Recommendation Report for Planning Permission for Works or Extension to a Dwelling**REF NO:** FG/42/17/HH**LOCATION:** 162 Littlehampton Road
Ferring**PROPOSAL:** Garage to front elevation with bedroom above (resubmission following FG/183/16/HH).**SITE AND SURROUNDINGS**

The application seeks planning permission for the construction of a 2 storey extension double garage with bedroom over forward of the front elevation of the dwelling within the front garden area, constructed of materials to match the existing dwelling with metal and upvc doors.

REFUSE

PROPOSED
GROUND FLOOR
LAYOUT PLAN
scale 1:100

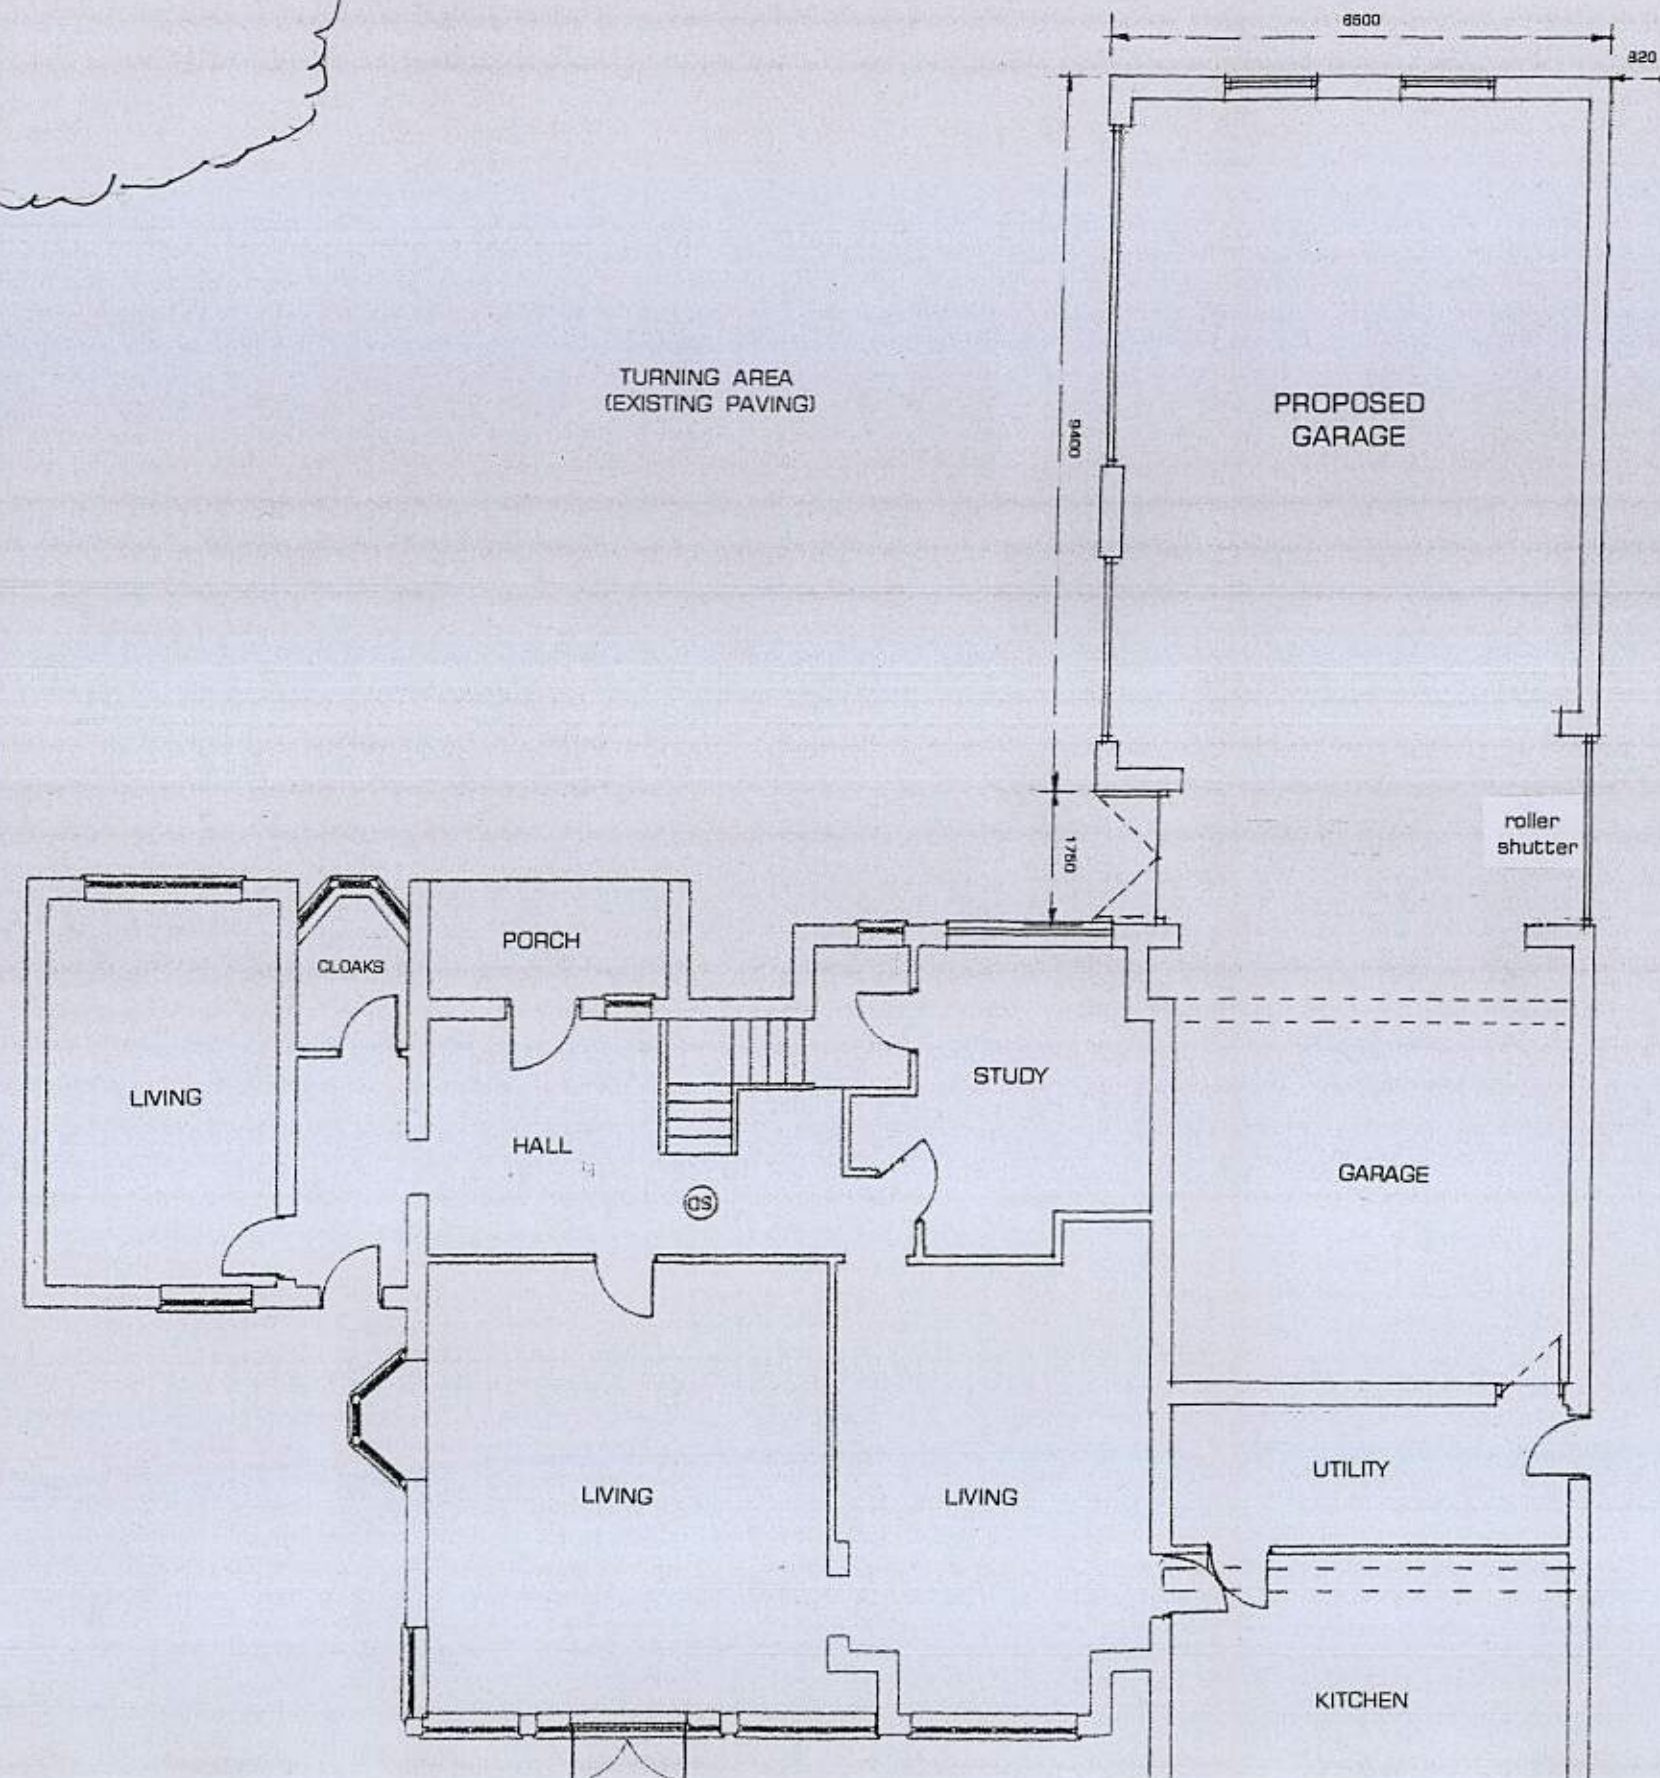
Although the proposed extension would be attached to the property and constructed forward of the existing dwelling there are other single storey garage structures similarly located to the east of the dwelling serving dwellings fronting Ancren Close and there is a high brick wall along the site frontage which screens the front garden area from public view. The lower garage portion of the extension was the subject of application FG/183/16/HH and would be well screened and not readily visible in the street scene and was considered to be acceptable in terms of its impact on visual amenity. However this proposal has increased the height and bulk of the roof and added a first floor which includes 3 dormer windows. This element would be readily visible from outside the site and would result in development at first floor level forward of the front elevation which would visually sit at odds with the other properties fronting Littlehampton Road, which have not been similarly extended, and would compromise the established spatial character and pattern of development in the street. It would be visually prominent and obtrusive in the street scene. Policy DEV19 (I) and (ii) of the Arun District Local Plan also requires extensions to be subservient and visually integrated with the host property. This proposal is considered to conflict with this requirement in that the design and form of the extension would compete with the existing dwelling. The dormers would be significant and would increase the visual prominence of the extension and detract from the balanced appearance of the existing dwelling in conflict with Policies GEN7(ii) of the Arun District Local Plan.

PROPOSED SIDE (EAST) ELEVATION

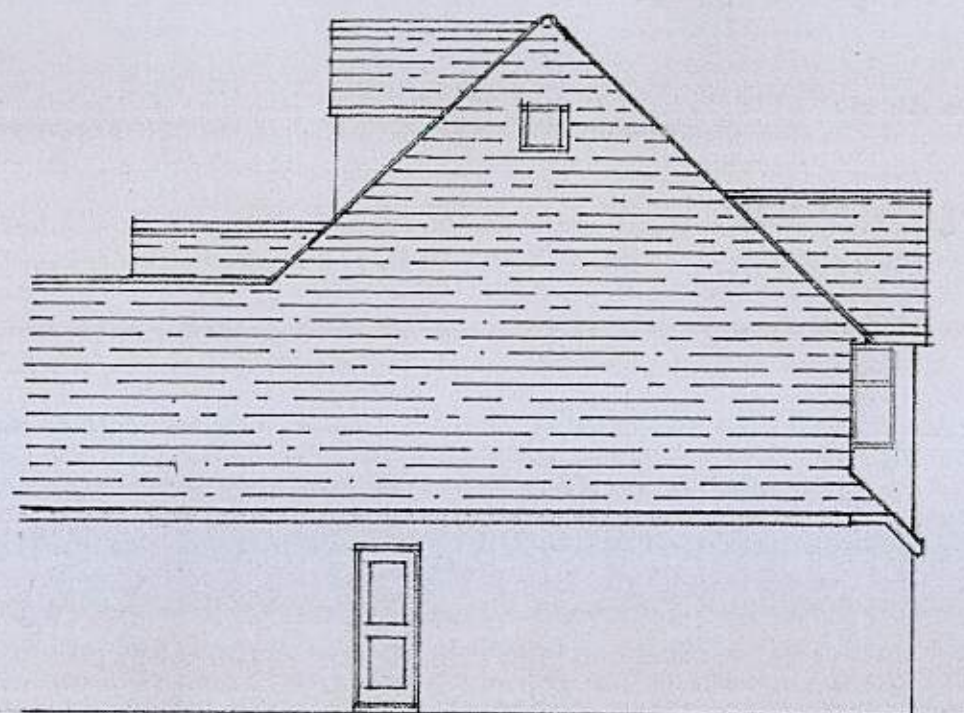
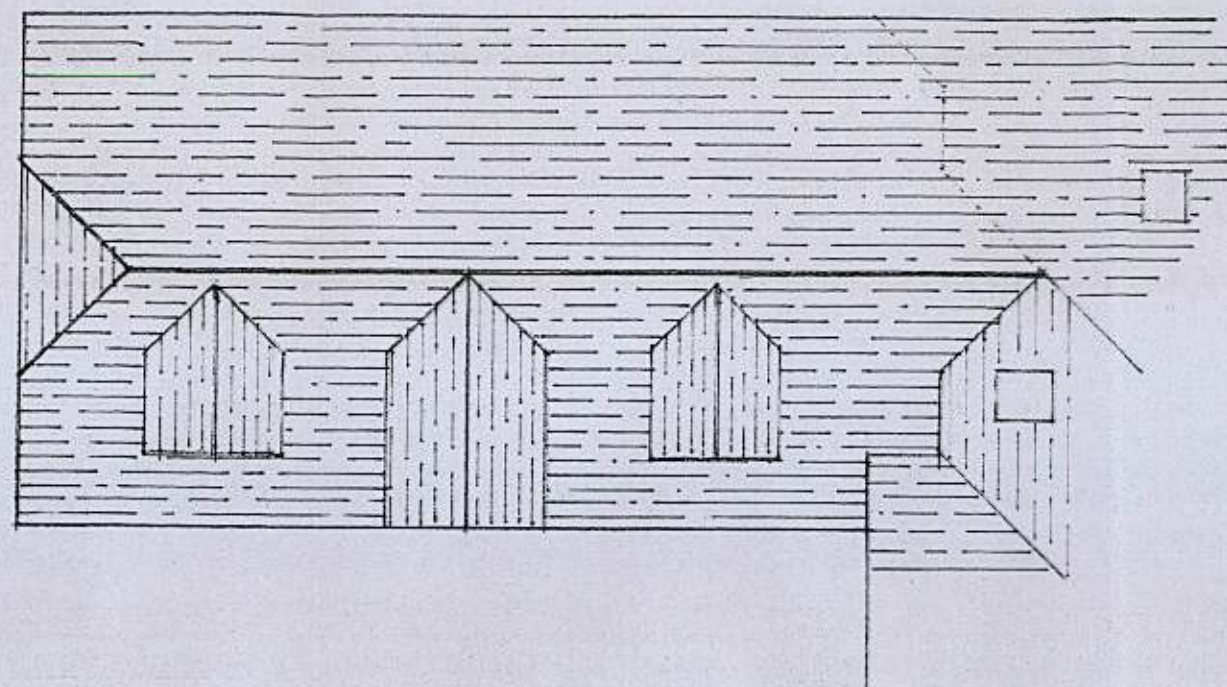
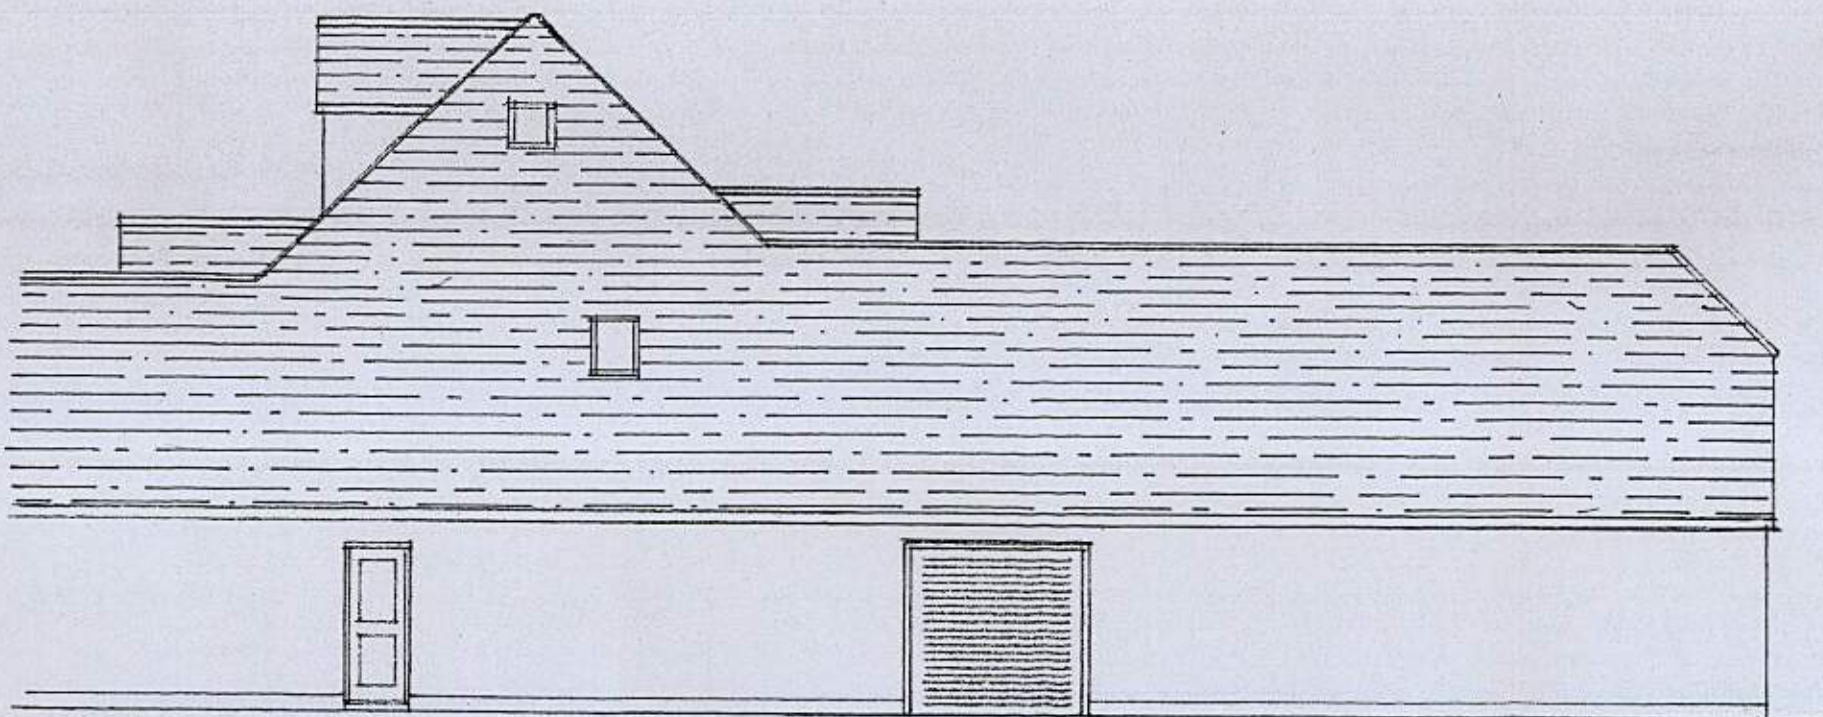
DESCRIPTION OF APPLICATION	As above. The proposal relates to a hipped roof double garage with bedroom above measuring 12.2m by 6.8m in area with a ridge height of 6.2m and an eaves height of 2.4m.
SITE AREA	N/A
RESIDENTIAL DEVELOPMENT DENSITY (NET)	N/A
TOPOGRAPHY	Predominantly flat
TREES	None of any significance affected by the proposed development.
BOUNDARY TREATMENT	Walling to approx. 2m encloses front garden
SITE CHARACTERISTICS	A single storey detached 2 storey dwelling with pitched roof and integral double garage to side not projecting forward of the dwelling.
CHARACTER OF LOCALITY	Predominantly residential characterised by detached dwellings of varying design in large plots set back a similar distance from the site frontage with the A259.

At its closest point the extension would be located 0.82m from the eastern boundary and the roof would pitch away from the shared boundary with an eaves height of 2.4m. The adjacent structures to the east are garages and any overbearing impacts would not therefore cause material harm to the residential amenities of the neighbouring properties in Ancren Close.

- 1 By reason of the height, design and size of the extension it would result in a prominent and obtrusive form of development which would appear out of keeping in the street scene and would not be subservient to the existing dwelling adversely affecting the visual amenities and character of the area in conflict with policies DEV19 and GEN7 of Arun District Local Plan.
